Re: Column Issue

Location: Lot 279 Atlantis at Serenity (68 Serene Crossing Fuquay-Varina, NC)
JDS Project No.: RDU2502643
Date of Inspection: 03/14/25

FRONT ELEV. "C"
1/8" = 1'-0"

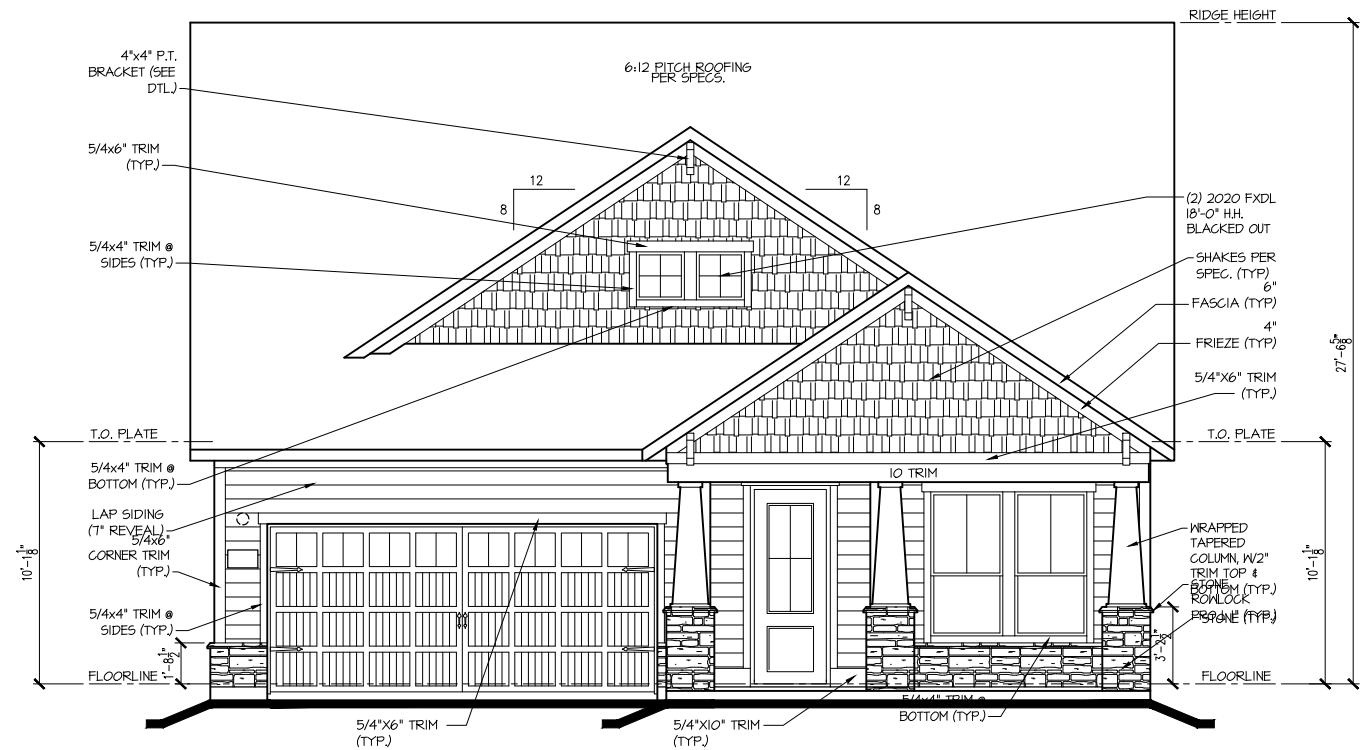
The client requests an evaluation of the left most front porch post. The client requests to move the post backwards approximately 1.25" and 1.75" to the right.

1. Move the post as desired.
2. Install a 3rd ply to the (2) 2x6 "drop beam" above the porch on the left wall attached with (3) rows of 10D nails spaced at 4' o.c.
3. Shave down the left to right roof trusses that ledger on the "drop beam" to fit onto the 3rd ply.
4. Install a 24"x24"x7/16" OSB gussets centered onto the bottom chord gusset plate connection point at the left end.
